RE: CoS Response to Submissions for SSD 7388 for the redevelopment of the IMAX Theatre and surrounds, 31 Wheat Road, Sydney

Attachment A - Reconciliation of City of Sydney issues raised in response to the exhibition of the redevelopment of the IMAX Theatre and surrounding public domain (SSD 7388)

PLOTTED BY: brendan.kilpatrick ON: 17/12/2015 AT: 1:28:17 PM 129018500-02-03-P2.dgn

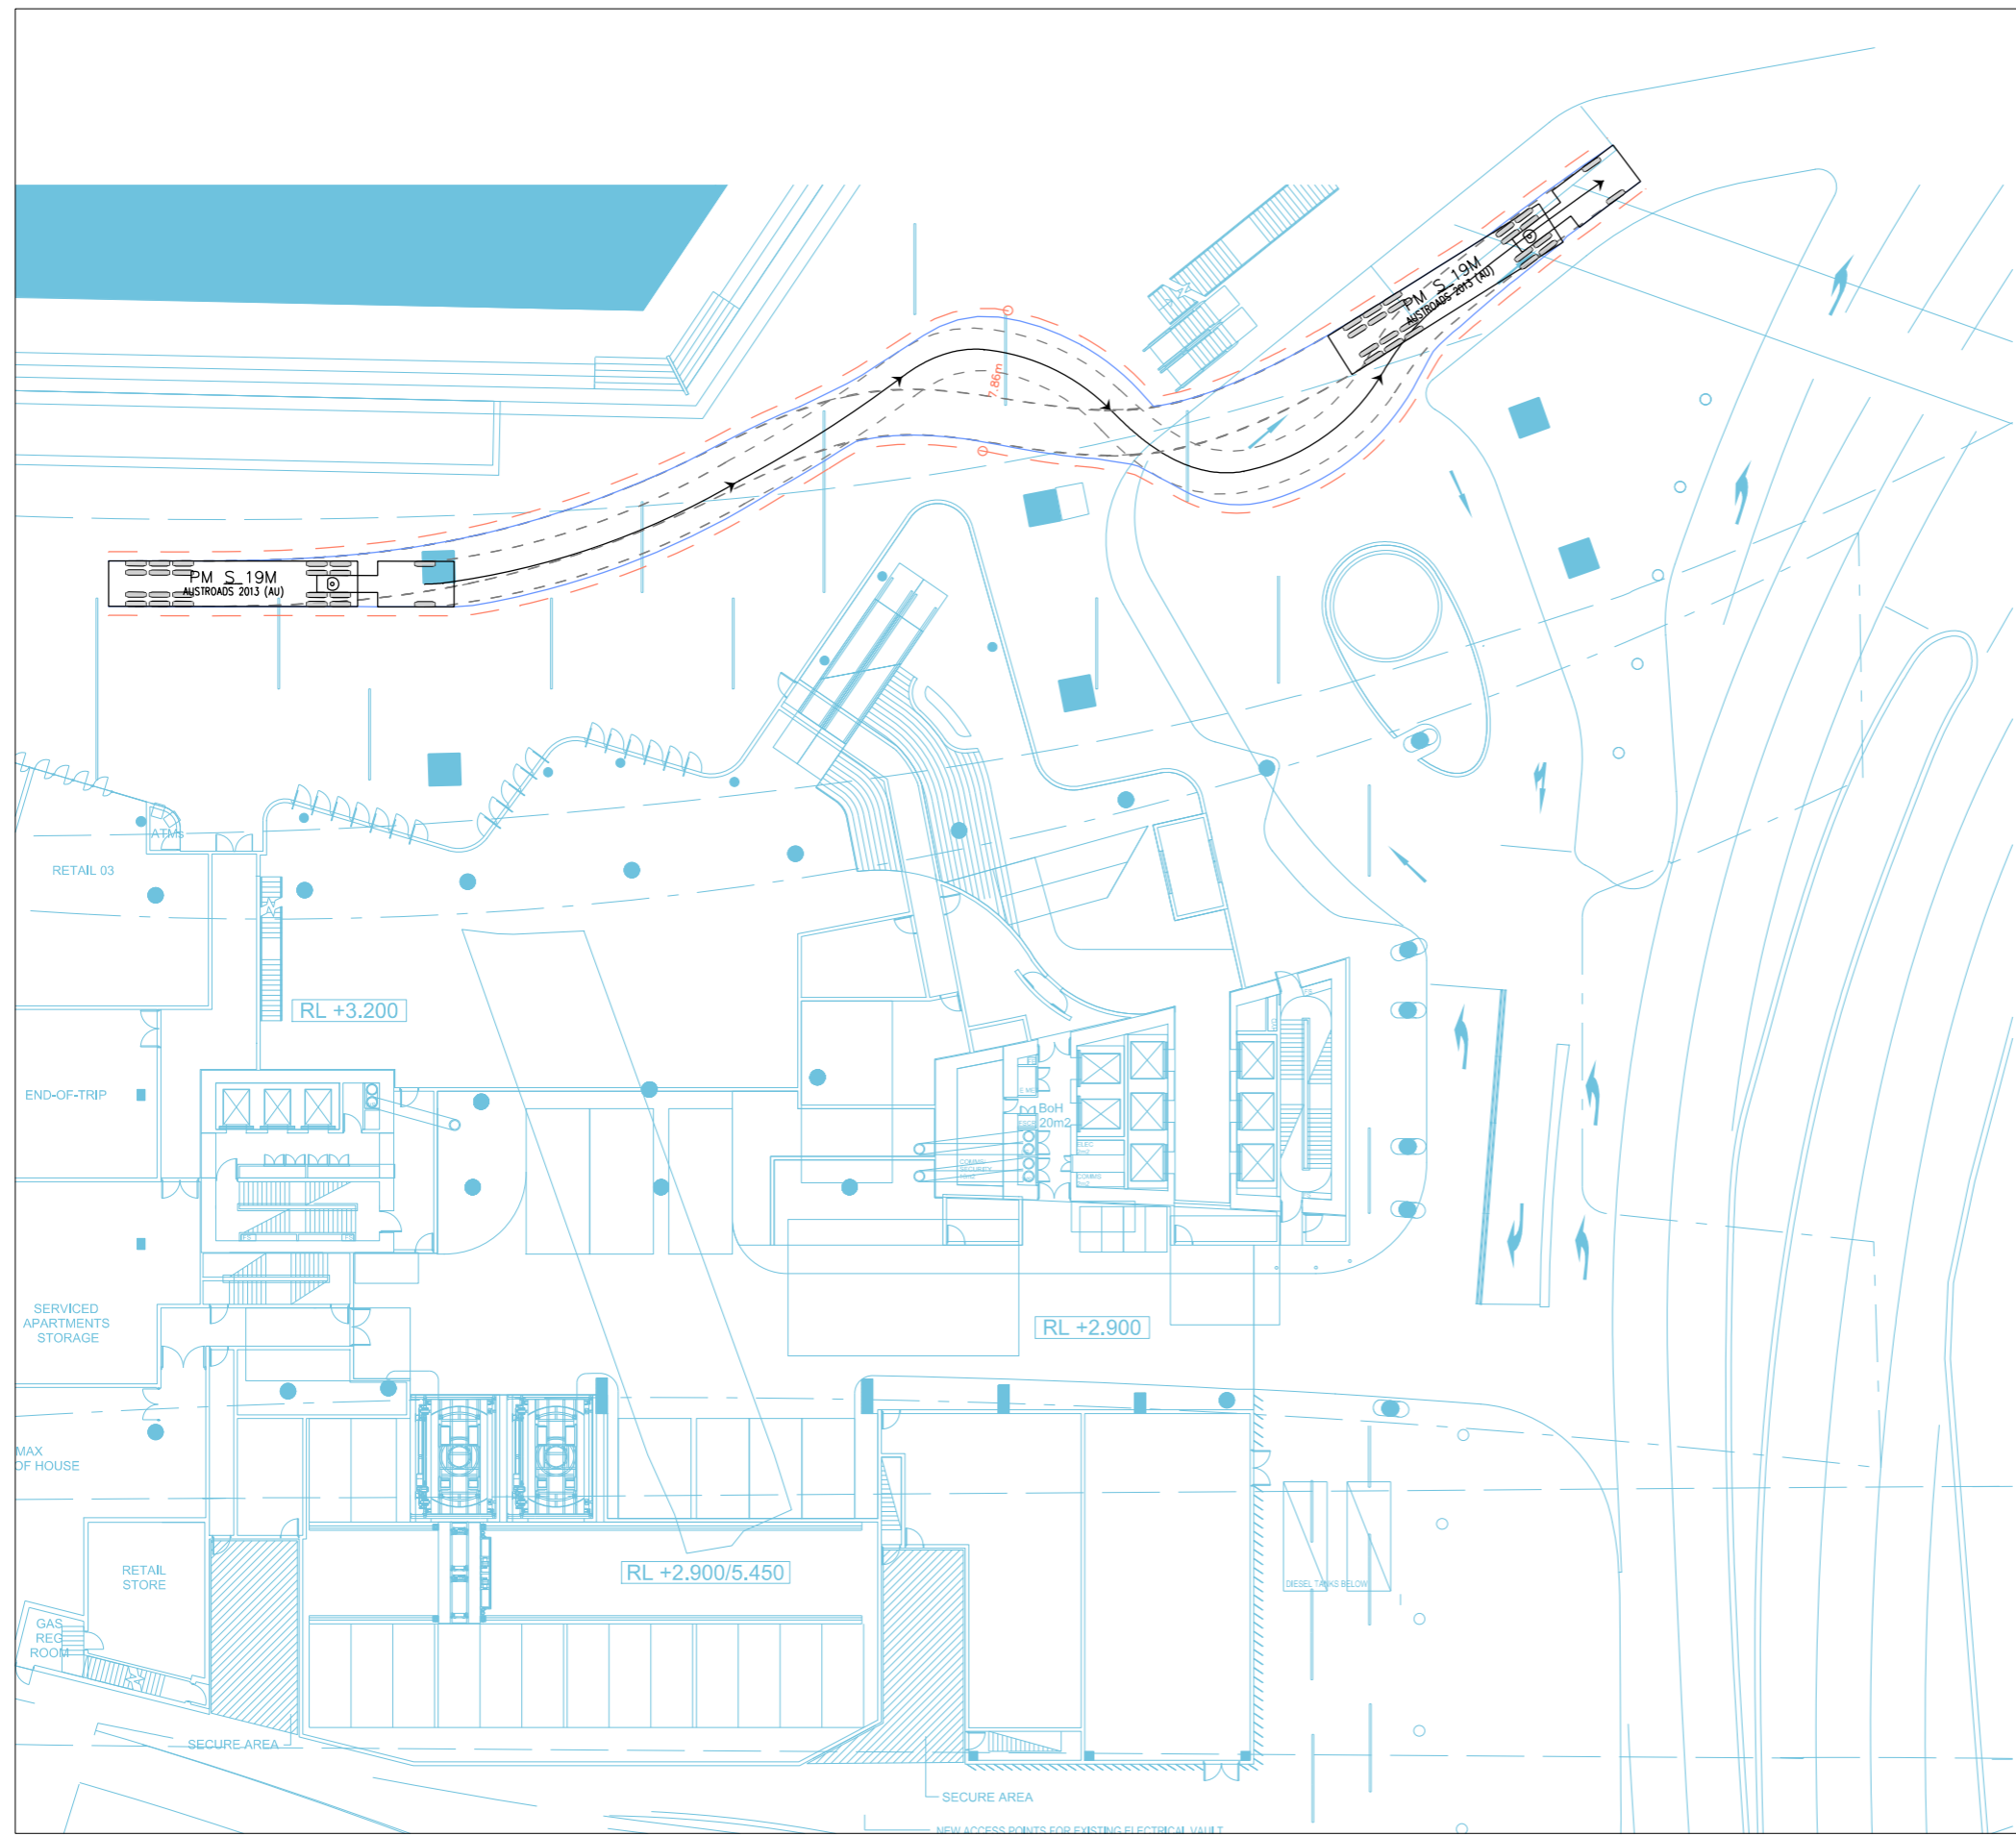
34. It is unclear what Appendix A, sheets 2 and 3 of the Traffic Impact Assessment are trying to demonstrate. Council does not support heavy rigid	No comment or response provided was provided to the specific issues raised by the City. The below comments have been provided in	No	It is understood that the 19m semi-trailer access via the waterfront area may be

Issue	Applicants response	Issues addressed?	City's contention
<p>vehicles such as semi-trailers entering the pedestrian footway area adjacent to the water front (if that is what is proposed). This area is highly pedestrianised and would not be suitable as a shared zone.</p>	<p>response to issues raised by Transport for NSW, who raised similar concerns to the City. <i>To maintain Darling Harbour special event access, the site incorporates the ability for a 19m semi-trailer to access the foreshore area. The associated swept paths to satisfy SHFA requirements were included with the Transport Impact Assessment and does not reflect day-to-day operation.</i></p>		<p>a SHFA requirement. The provision of 19m semi-trailer access via the waterfront area is not supported by Council.</p>
<p>35. A Loading Management Plan should be provided to demonstrate how the dock will be managed. The on-site loading area is to be available to all tenancies of the particular building (i.e. hotel, lounge bar, restaurant, service apartments, shopping, retail, function centre, cinema etc). This shall be managed either by a schedule showing all tenants when they can use the area, or by a register managed on site to allow tenants and residents to reserve a time period for their deliveries.</p>	<p>No comment or response provided was provided to the specific issues raised by the City. The below comments have been provided in response to issues raised by Transport for NSW, who raised similar concerns to the City. <i>A detailed management plan for the porte cochere and car stacker/ loading area would be prepared as discussed previously to address any potential conflict between any loading vehicles and car stacker queued vehicles. Loading and unloading will be undertaken outside of peak hours (where possible) when there is limited demand for the car stacker. It is also anticipated that service vehicles would be able to travel adjacent to any queued vehicles in order to access the loading area. Vehicle manoeuvring in the basement area would be managed by an attendant or security personnel. The vehicle positions shown within the porte cochere vehicle bays are indicative only. The bus swept path is a worst case situation (14.5m long rigid bus which are not used the Sydney Explorer service and would only be occasional pre-arranged coaches for the hotel). The swept path analysis shows there is adequate spare width within the porte cochere area for a 14.5m long rigid bus to pass parked vehicles, however the resultant vehicle positioning at the bus stop would be considered further during detailed design to deliver an appropriate outcome.</i></p>		<p>As noted above, concerns are raised that there is not the vehicle capacity to address all the vehicle access needs of the site. A loading management should be provided up front so a proper assessment of the feasibility of the plan can be determined. As discussed previously, the management plan must address the cumulative impact and management of the porte cochere, car stacker and loading area and address any potential conflict between uses such as conflicts between queuing loading vehicles and car stacker vehicles. In this regard, the queuing of vehicles waiting to use the mechanical stacker is not supported within a loading dock area. Alternatively, the queuing of service vehicles within the loading dock is also not supported.</p>
